Please ask for: Nicola Moore
Email: nicola.moore@arun.gov.uk
Telephone: Ext 37944
Our Ref: BR/122/20/OUT
Your Ref:
Date: 9th June 2020

Application for Outline Planning Permission

Development: demolition of garth house and west view to be replaced with 20 self contained apartments
Location: Garth House High Street Bognor Regis PO21 1HQ

Proposed Ground Floor Plan

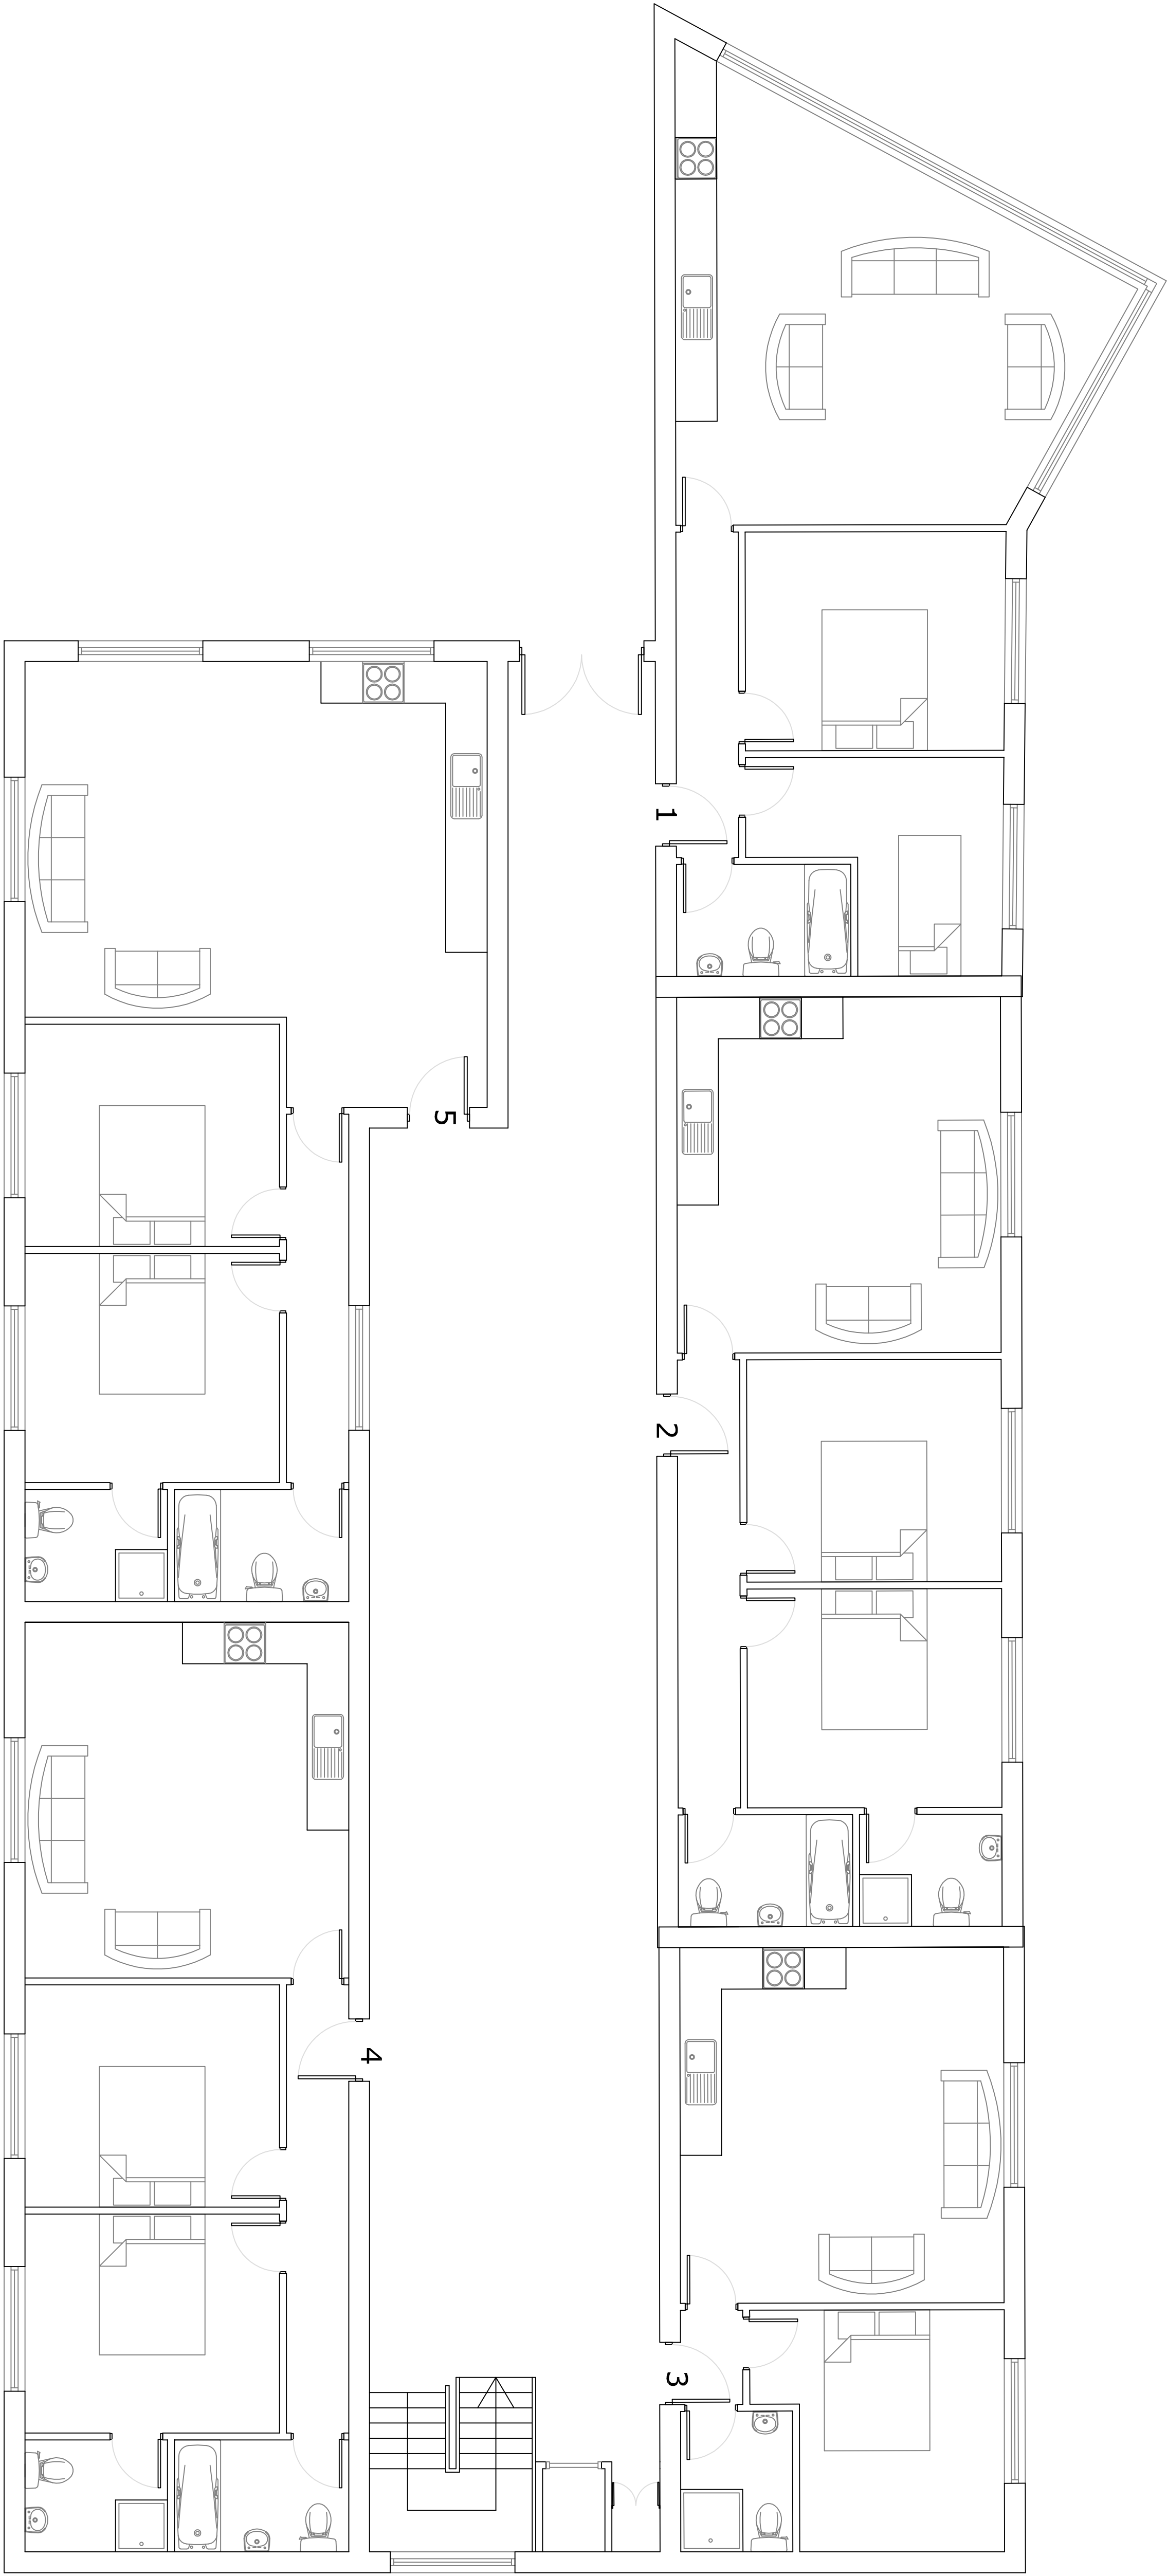
Please identify what provision has been made for the storage of waste & recycling and demonstrate that these aid the collection of waste & recycling measures by the waste collection authority. The location of waste storage & recycling facilities should be clearly identified on the plans.

1:200 1:1250

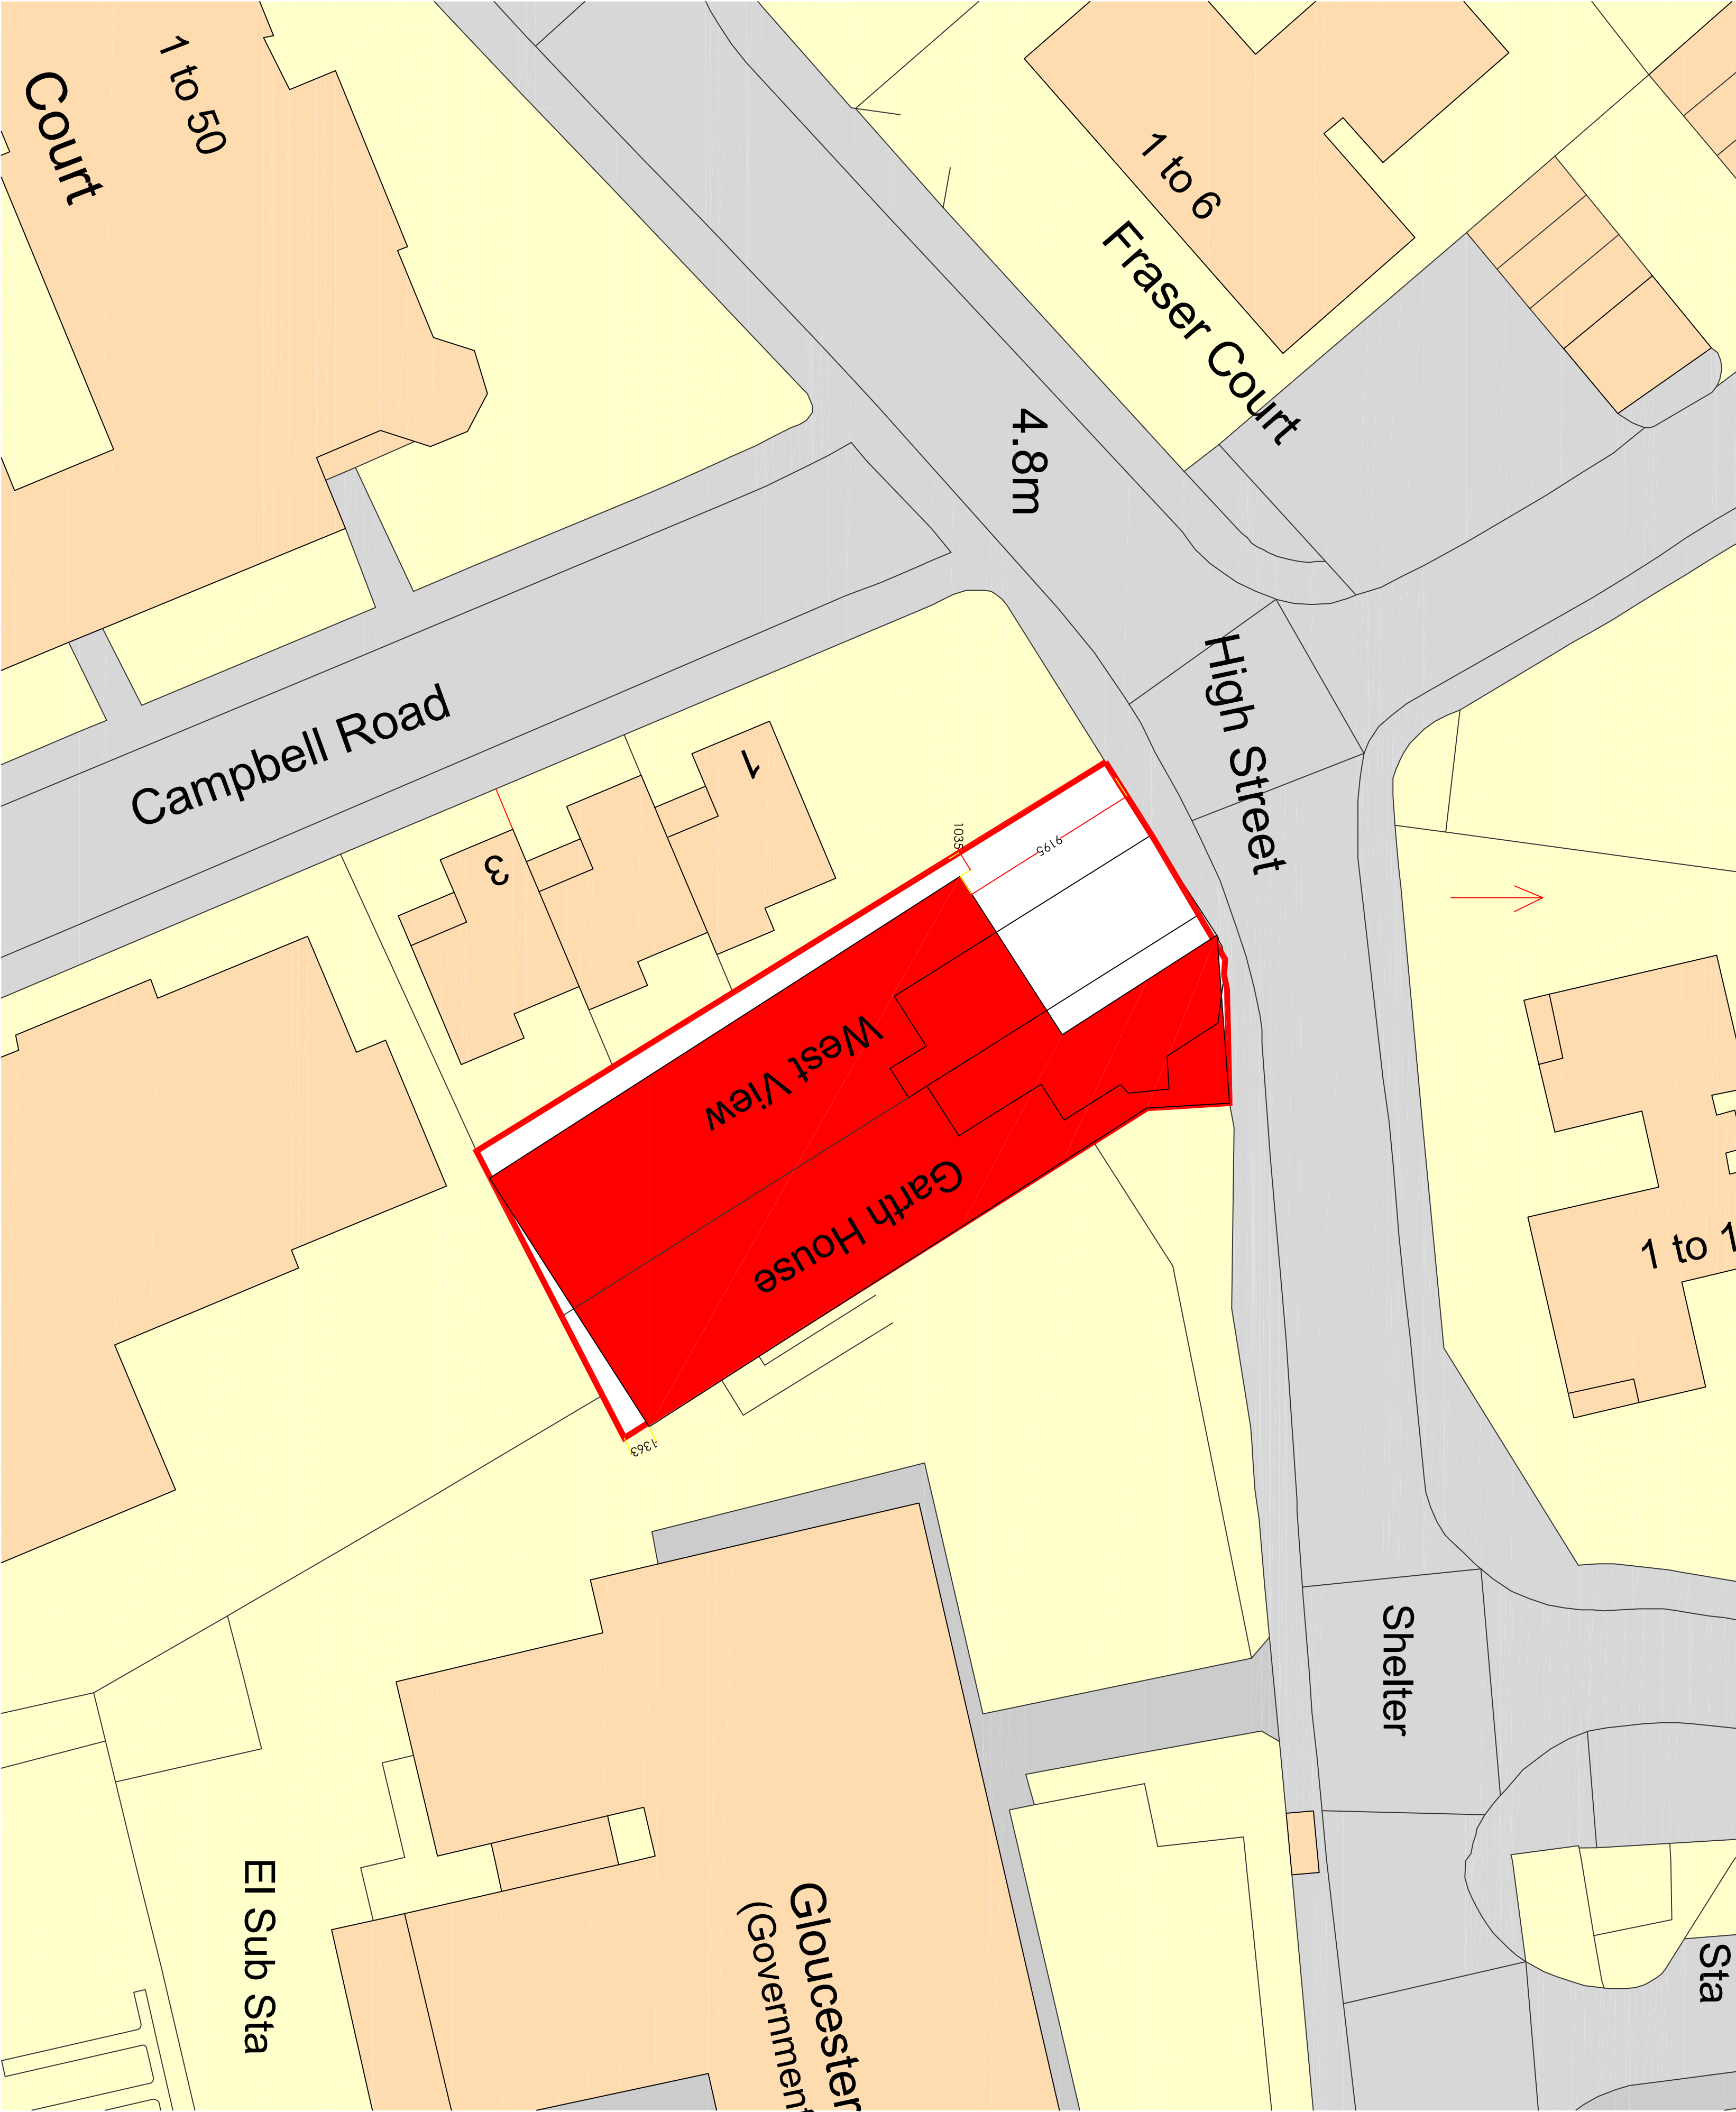
Please amend the Location Plan to include road names and show the direction of North. Also remove any red edges that are not applicable to the application site. Please re submit at a scale of 1:1250 or 1:2500

Please amend the Block Plan to show the direction of North and remove red edges that are not applicable to the application site. The Block plan should also include the footprint of the demolished building/s and all measurements to boundaries of the proposed development. Please submit at a scale of 1:500 or 1:200
